Our Reference: SYD18/00975/03

Department Ref: SSD 9403

**EXHIBITION OF RESIDENTIAL DEVELOPMENT  
1 & 2 MURRAY ROSE AVENUE, SYDNEY OLYMPIC PARK (SSD 9403)**

DRAWING TITLE:
Building 1
Preliminary Parking and
Access Assessment
Basement 1

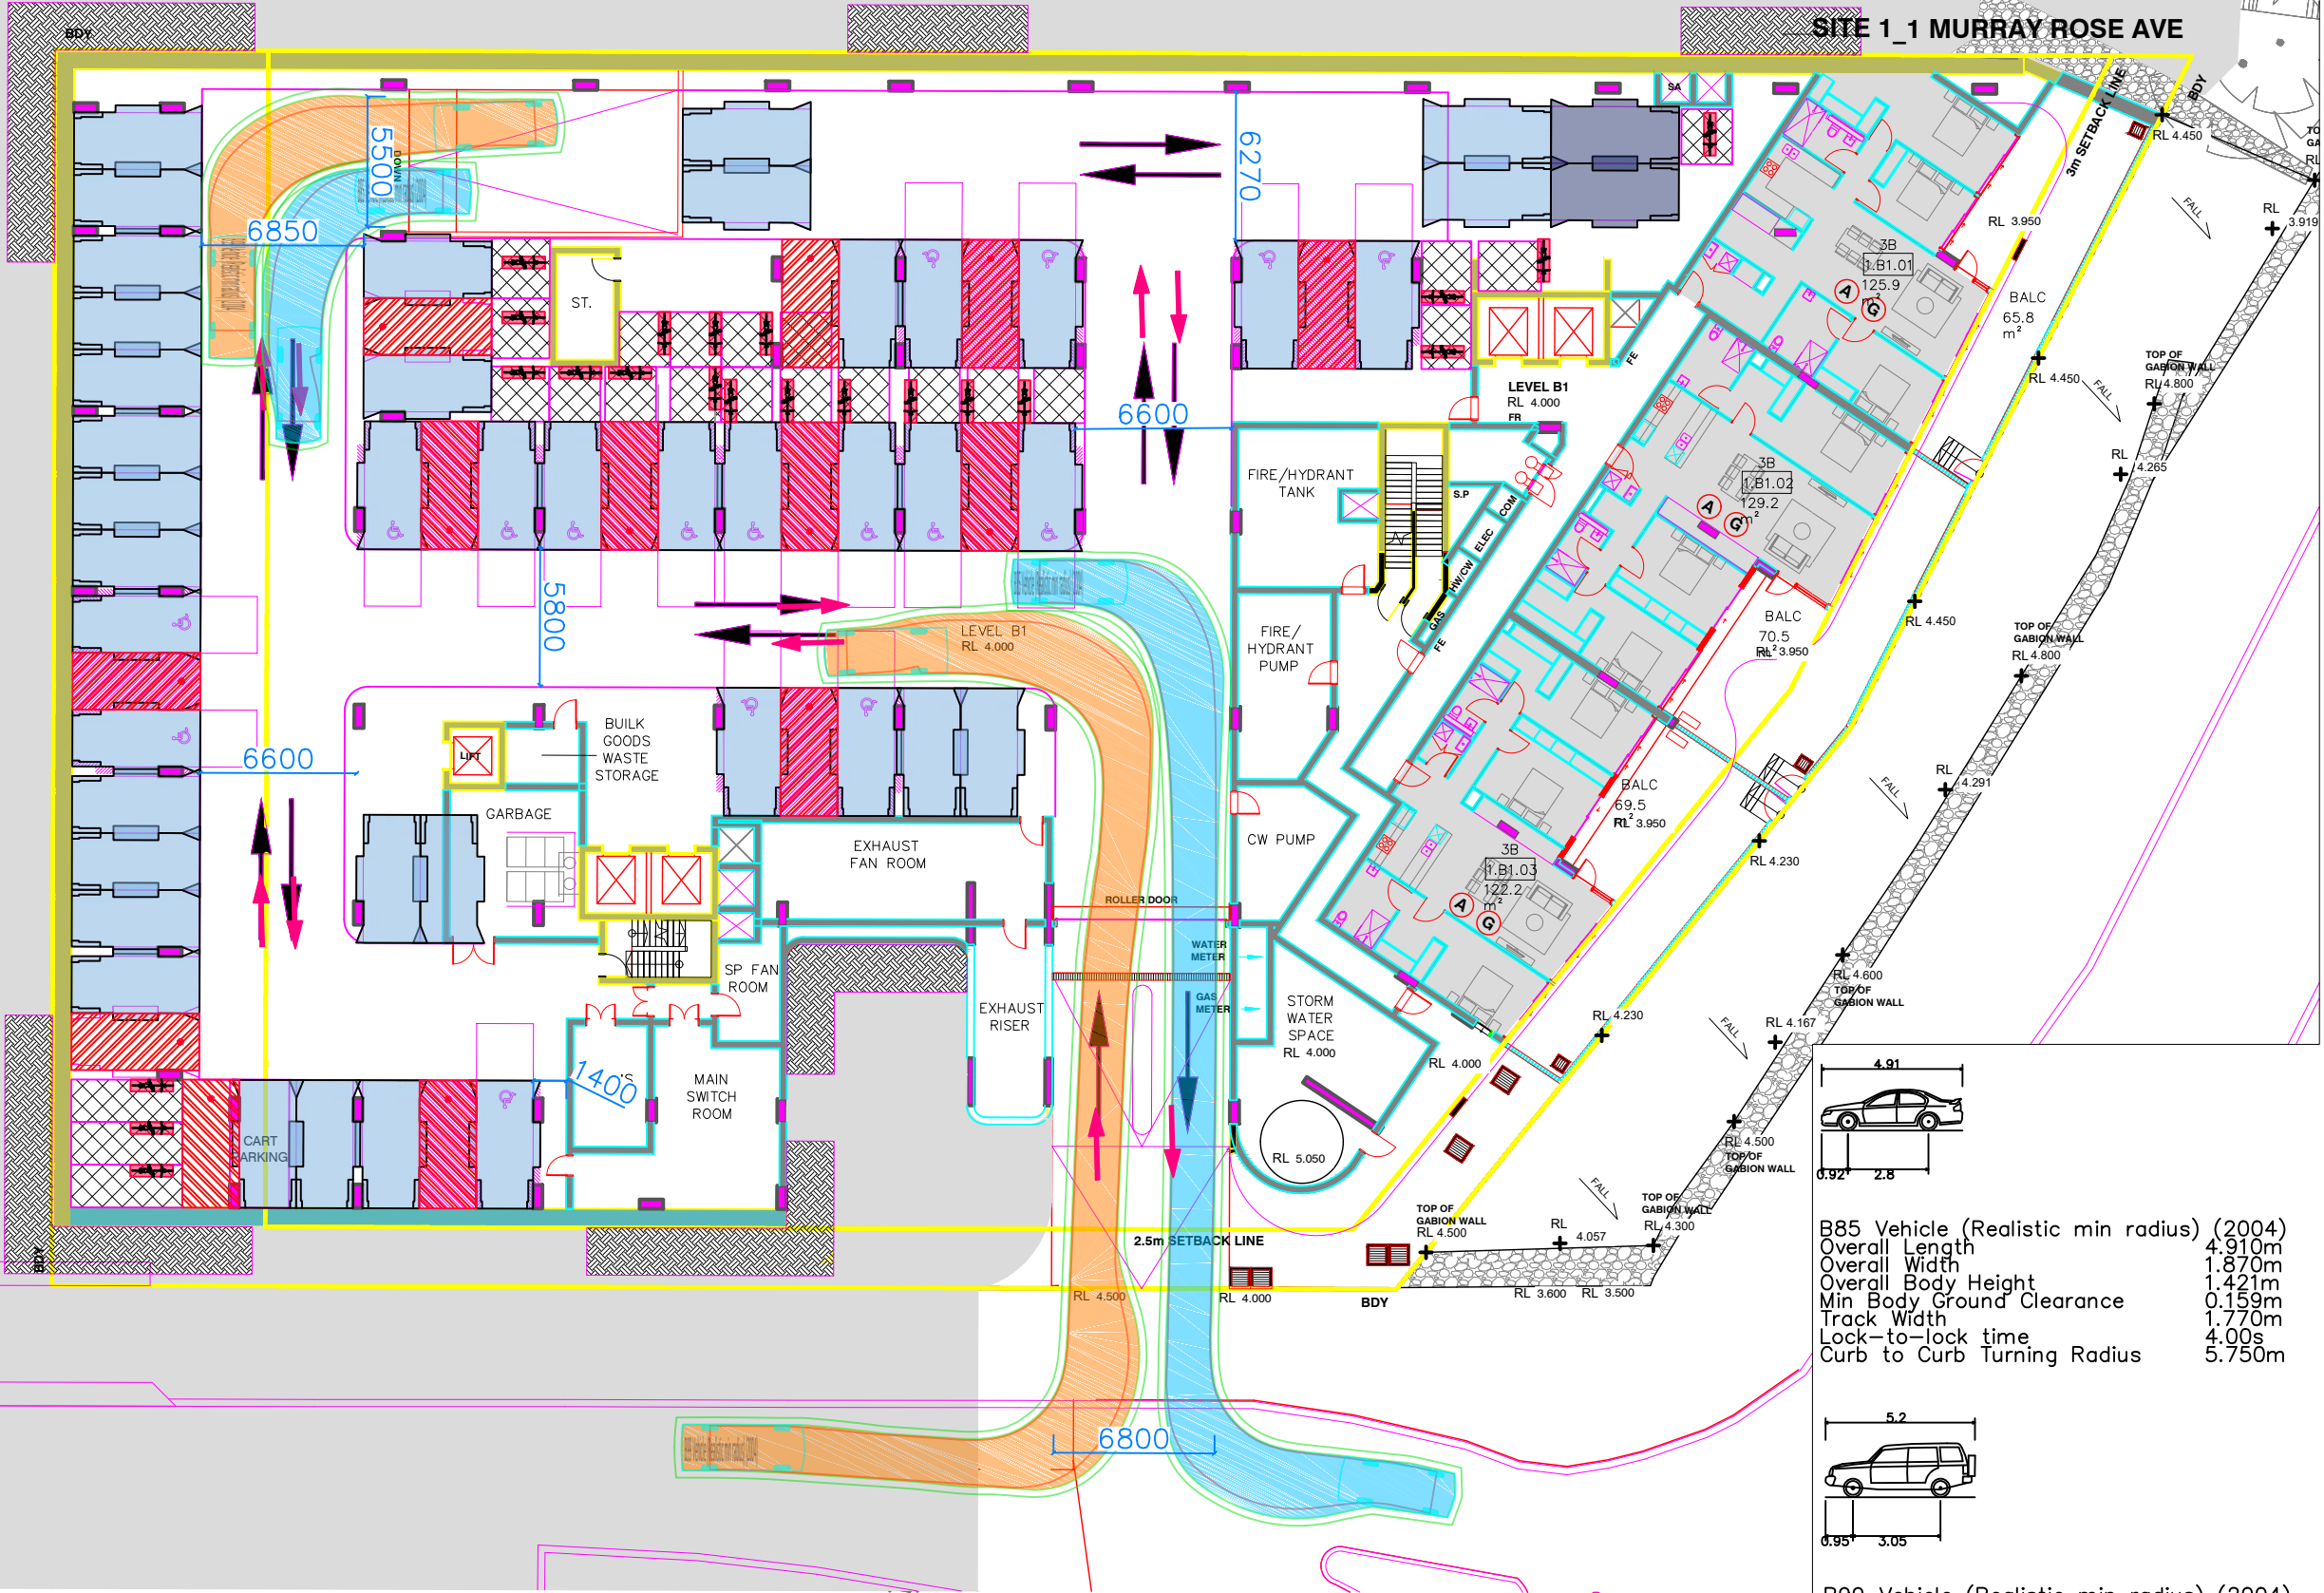
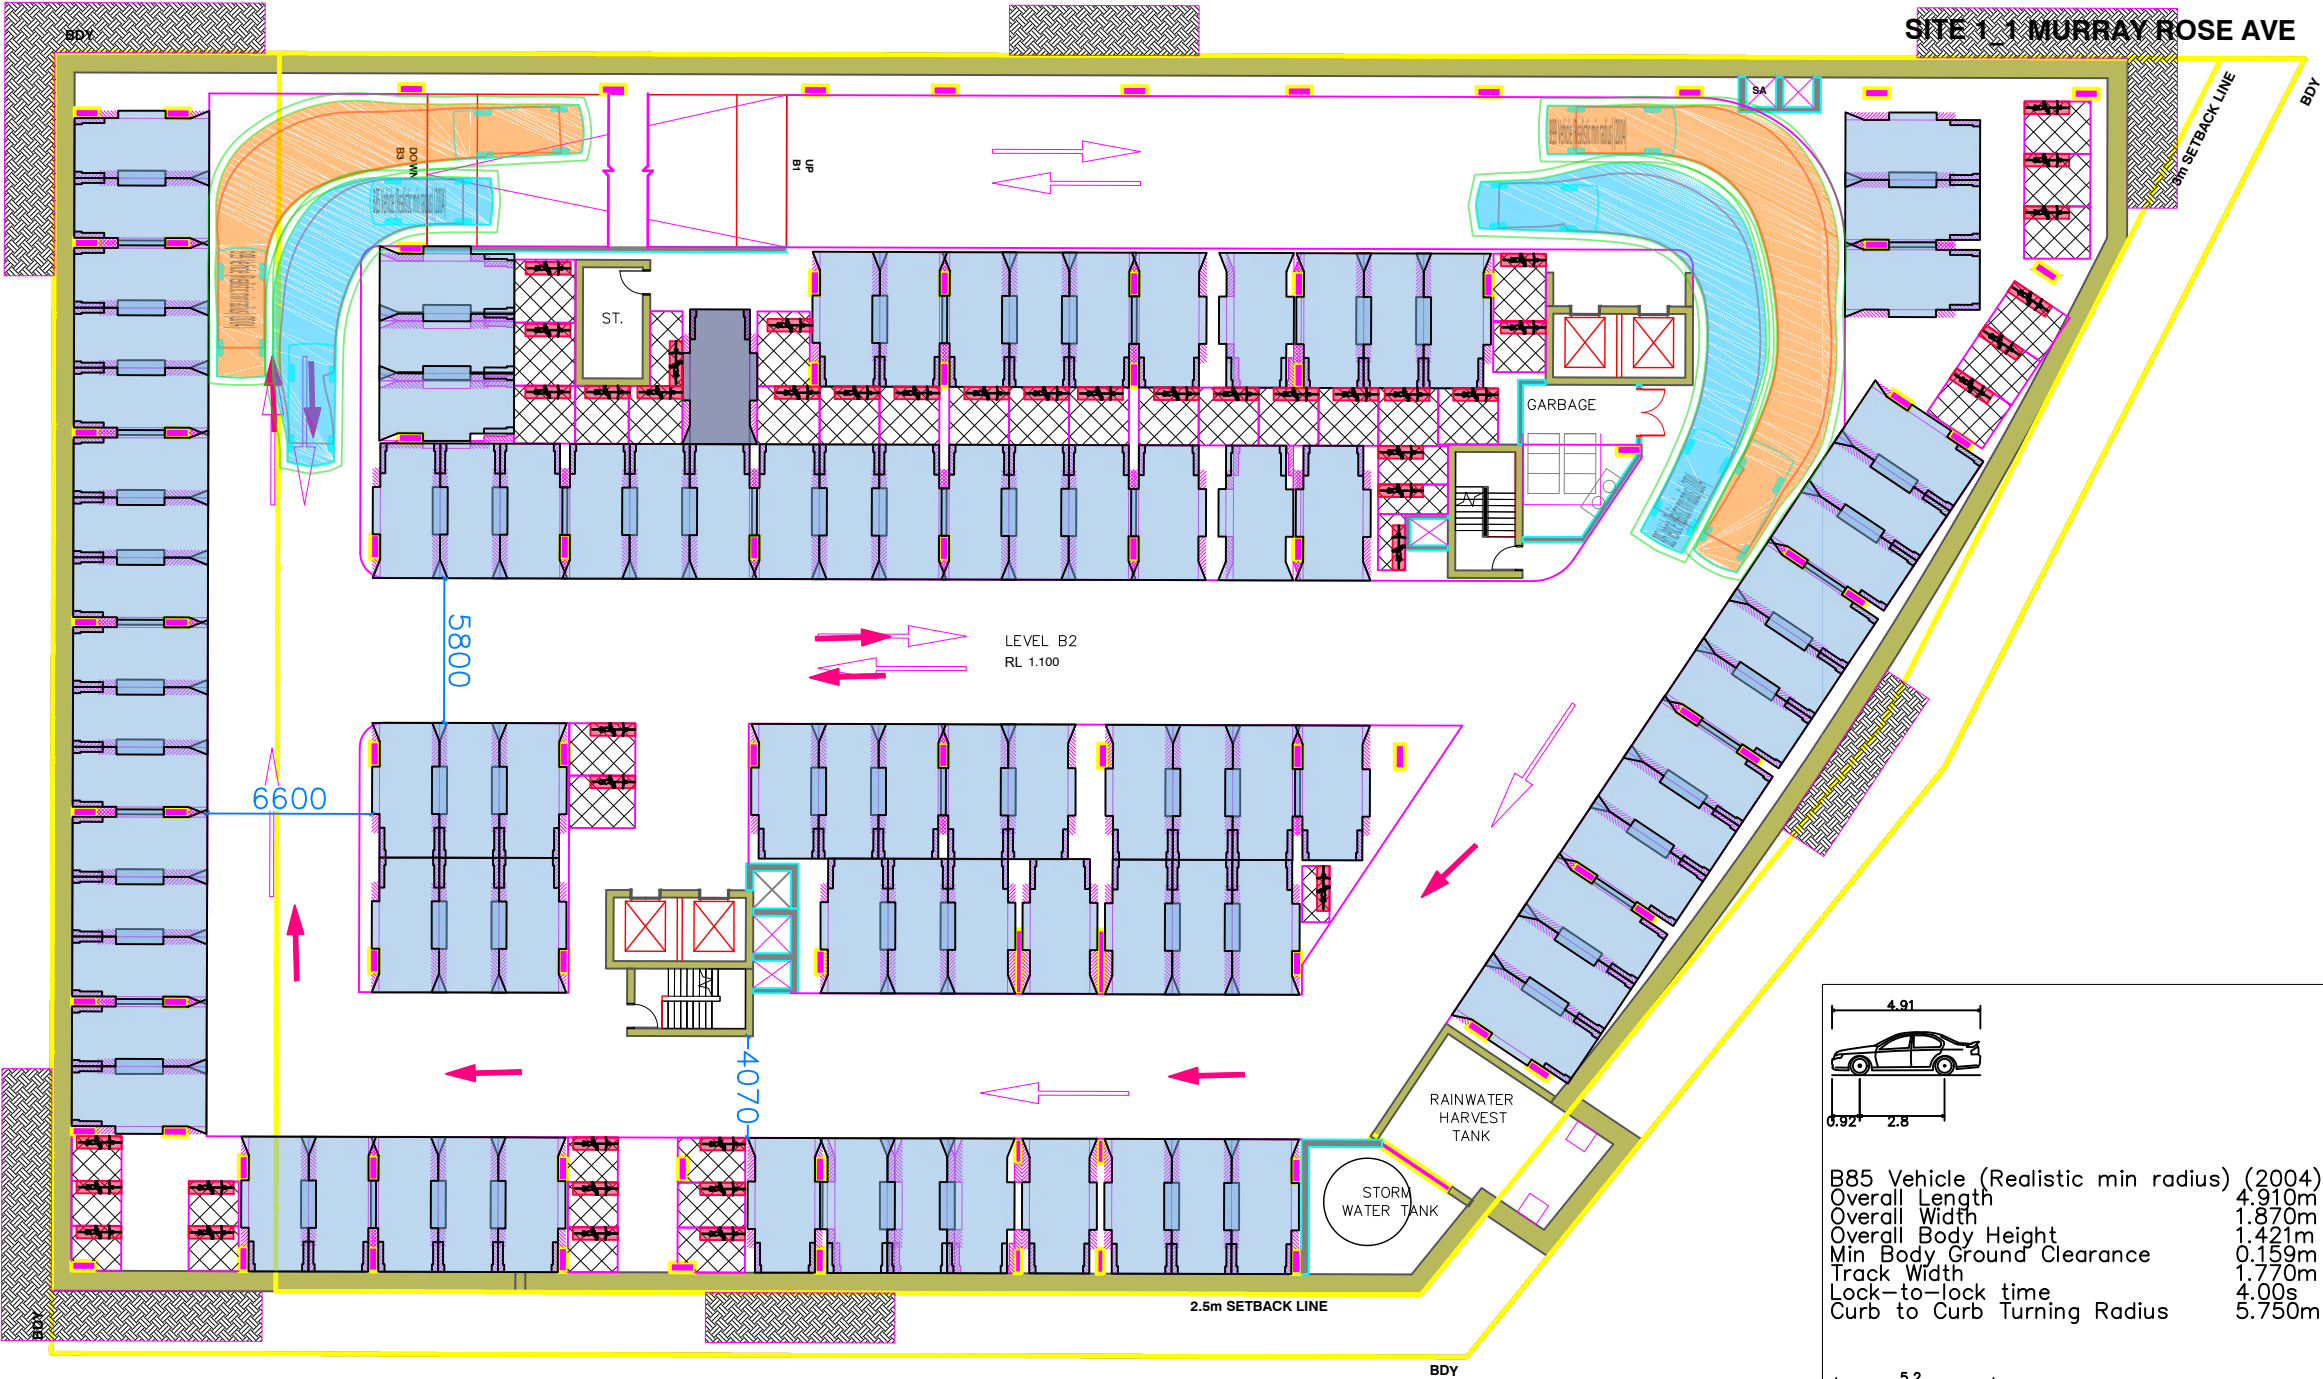
1. The layout of the proposed car parking areas associated with the subject development (including, driveways, grades, turn paths, sight distance requirements in relation to landscaping and/or fencing, aisle widths, aisle lengths, and parking bay dimensions) should be in accordance with AS 2890.1- 2004, AS2890.6-2009 and AS 2890.2 – 2002 for heavy vehicle usage. Parking Restrictions may be required to maintain the required sight distances at the driveway.

2. Bicycle parking should be provided in accordance with AS2890.3.
3. The swept path of the longest vehicle (including garbage trucks, building maintenance vehicles and removalists) entering and exiting the subject site, as well as manoeuvrability through the site, shall be in accordance with AUSTROADS. In this regard, a plan shall be submitted to Council for approval, which shows that the proposed development complies with this requirement.

4. All vehicles are to enter and leave the site in a forward direction.
5. All vehicles are to be wholly contained on site before being required to stop.
